RE: Clint Short Plat SP-08-00054

SUBJECT: Clint Short Plat SP-08-00054  
REVISED COMMENTS

SUBJECT: Clint Short Plat SP-08-00054

RE: Clint Short Plat (SP-08-00054)

CLINT SHORT PLAT

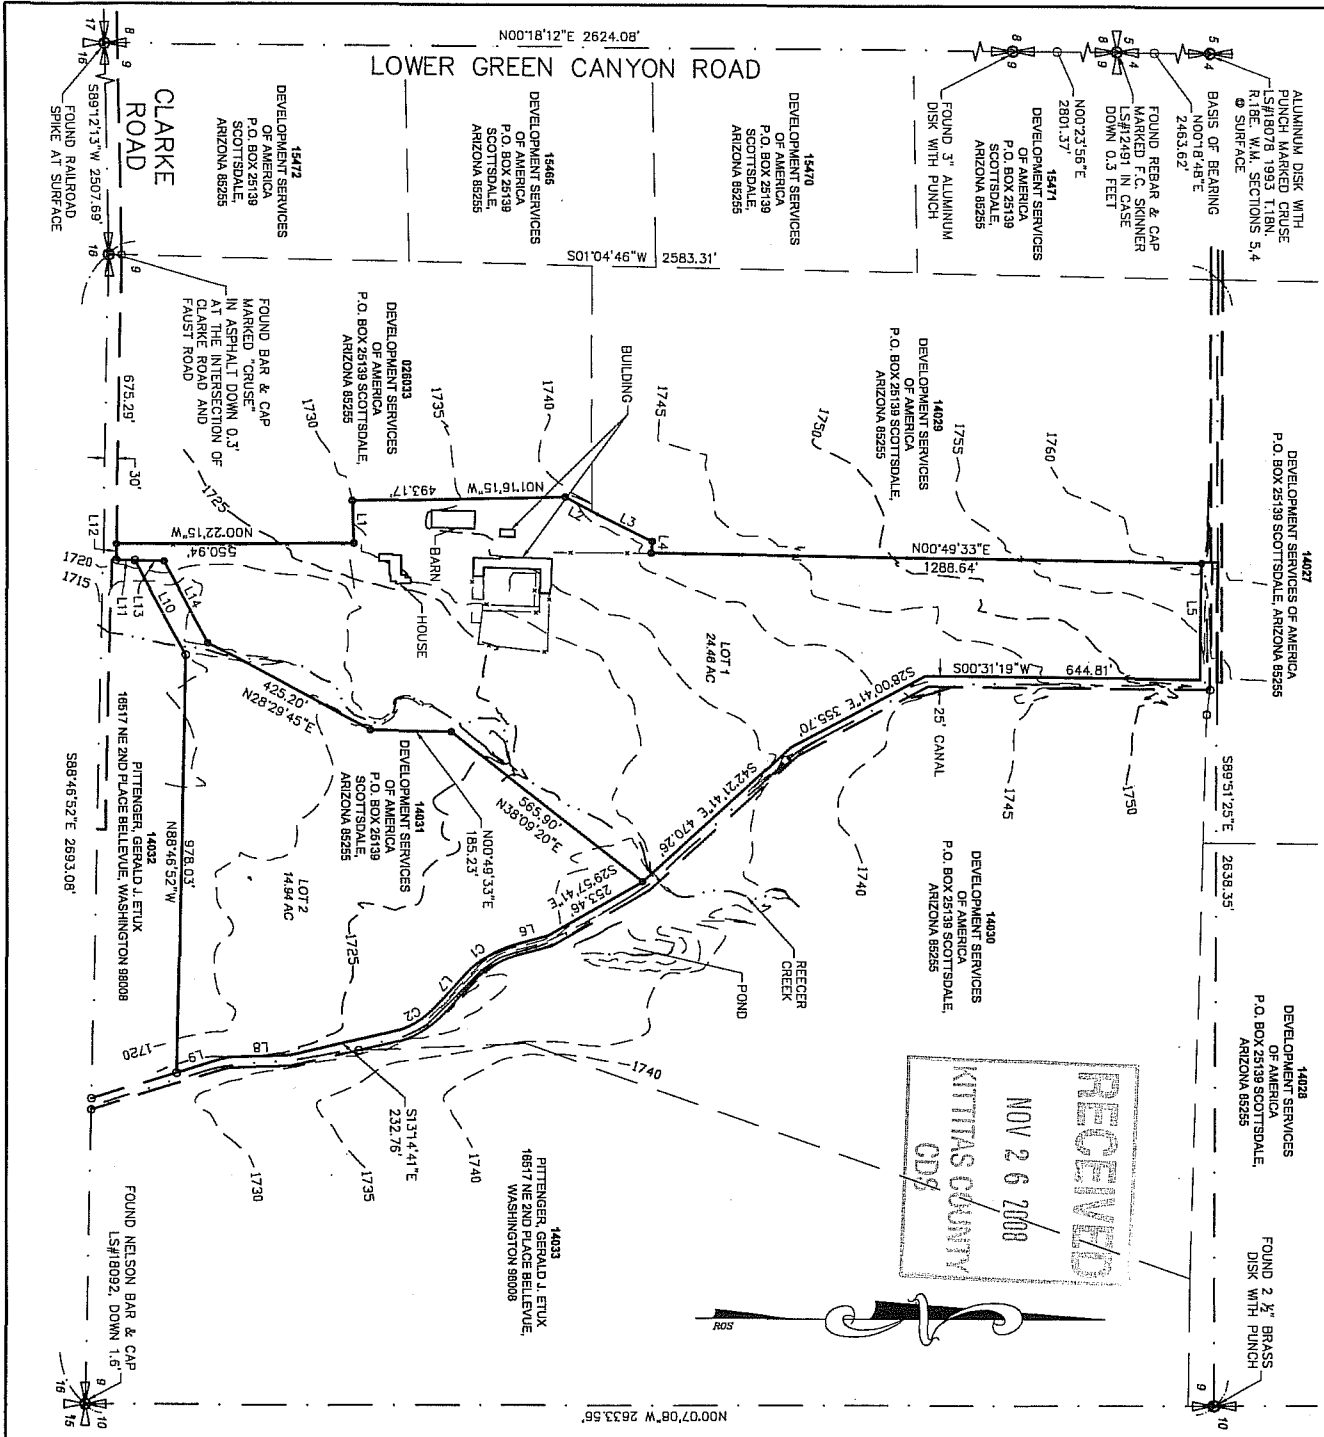
3. Clarke Road Right of Way: The entire Clarke Road right of way shall be shown. The right of way shall be clearly delineated to avoid confusion between lot lines and section lines.
4. Plat Approvals: All plats must show the acceptance signature of the County Engineer. The acceptance block shall be as follows (per KCC 16.24.170):

- Please have the applicant re-submit the plat drawing to reflect the location of the existing well.
- The potable water plat note is incorrect (plat note #6). Please replace the plat note with the following:
